Our Ref: P/47/11/
Your Ref:

Single storey extensions
52 East Front Road Pagham

I regret that I am unable to accept your documents as a formal application until the following matters have been resolved :-

SITE/BLOCK PLAN 1:200

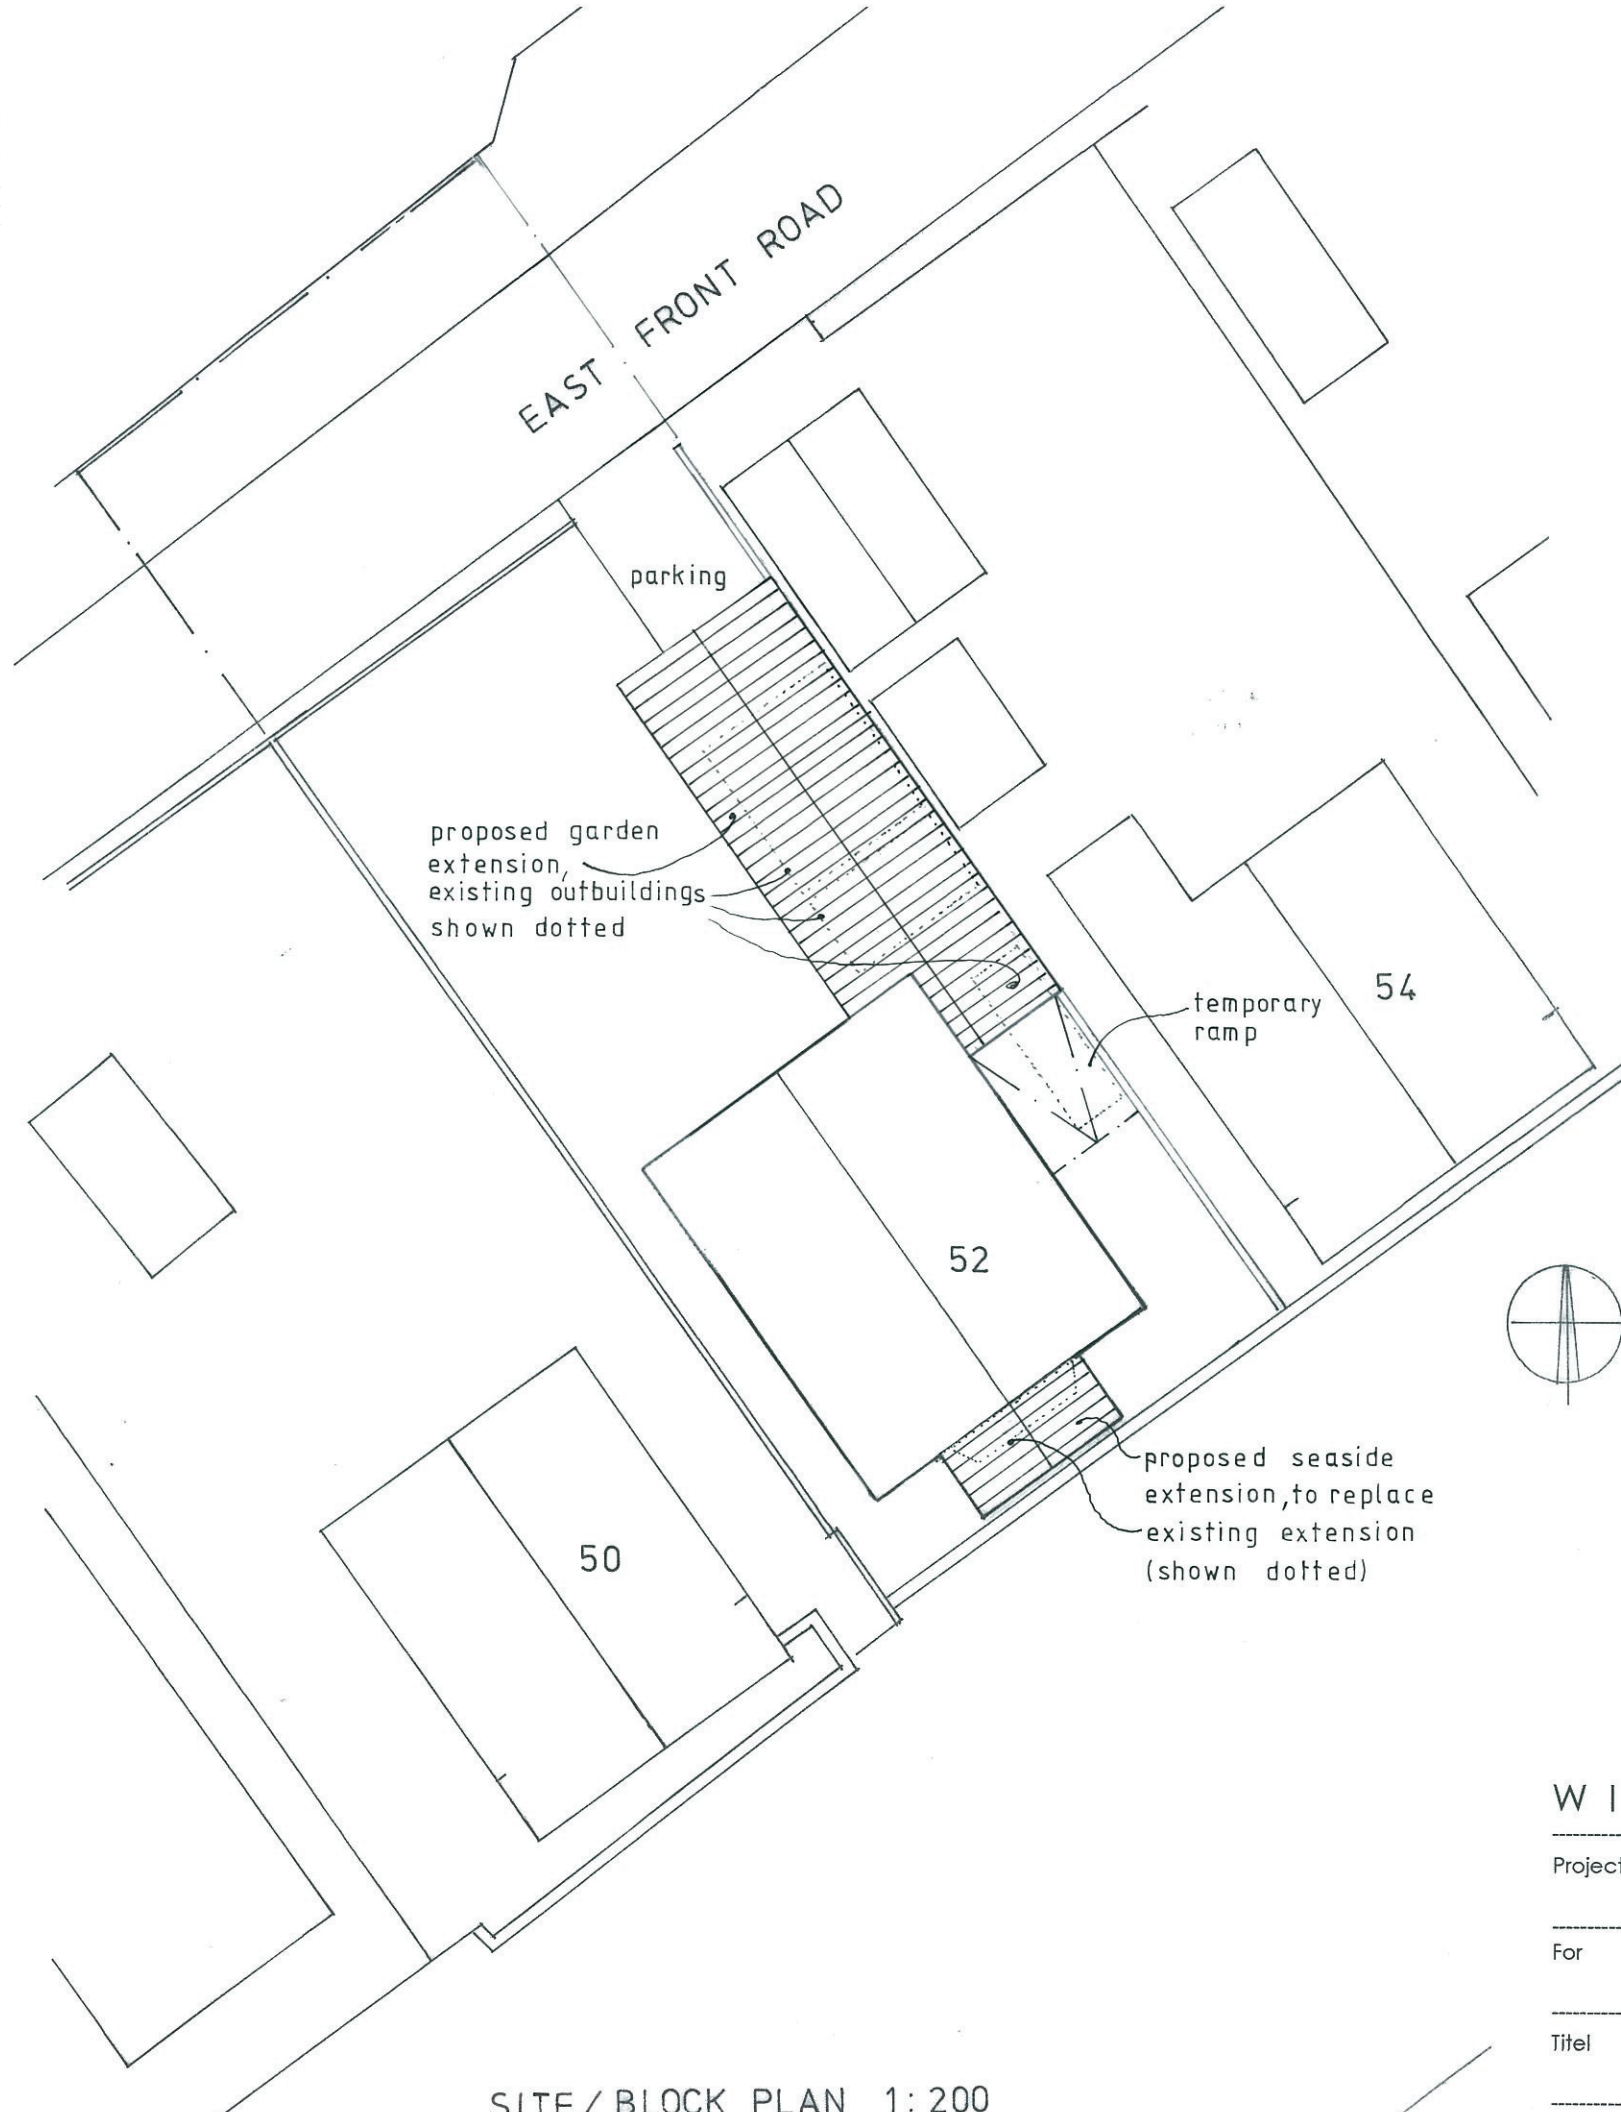
I require 1 electronic or 3 paper copies of a revised block/site plan showing the proposed works clearly highlighted, in accordance with the guidance notes available on our website detailed below (click on National List).

LOCATION PLAN 1:1250

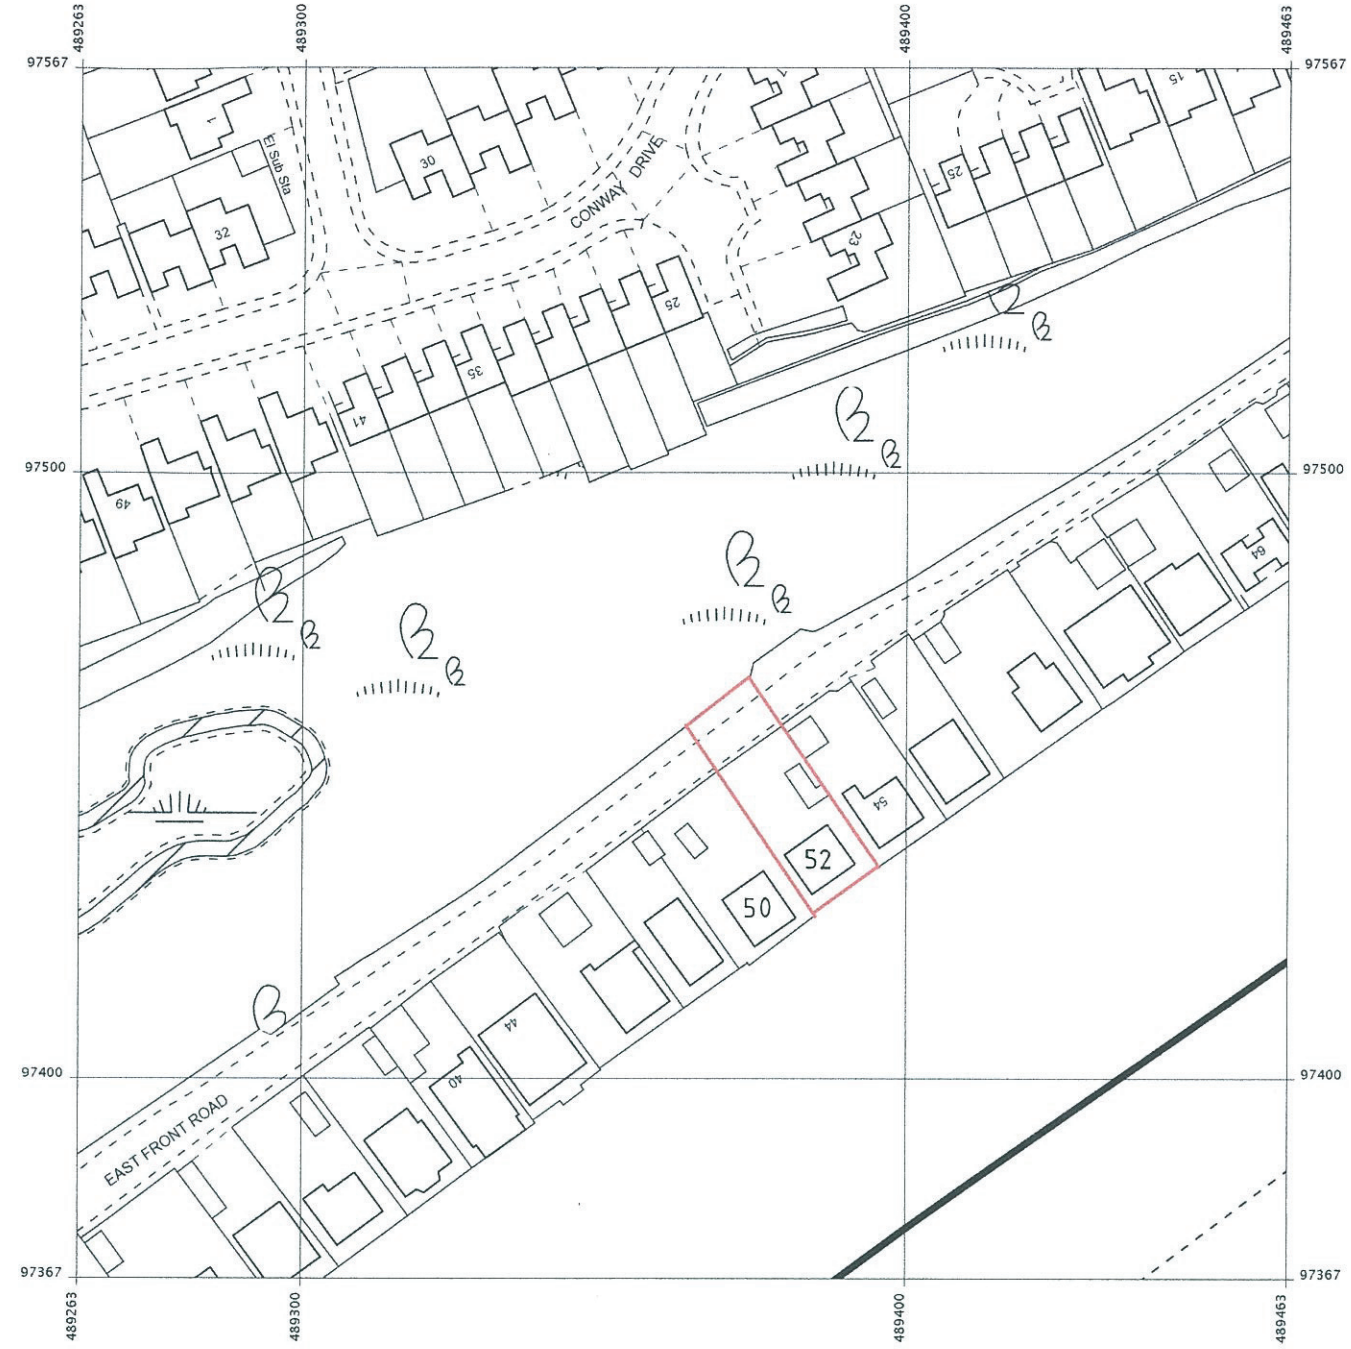
I require 1 electronic or 3 paper copies of a revised location plan showing another named road, in accordance with the guidance notes available on our website detailed below (click on National List).
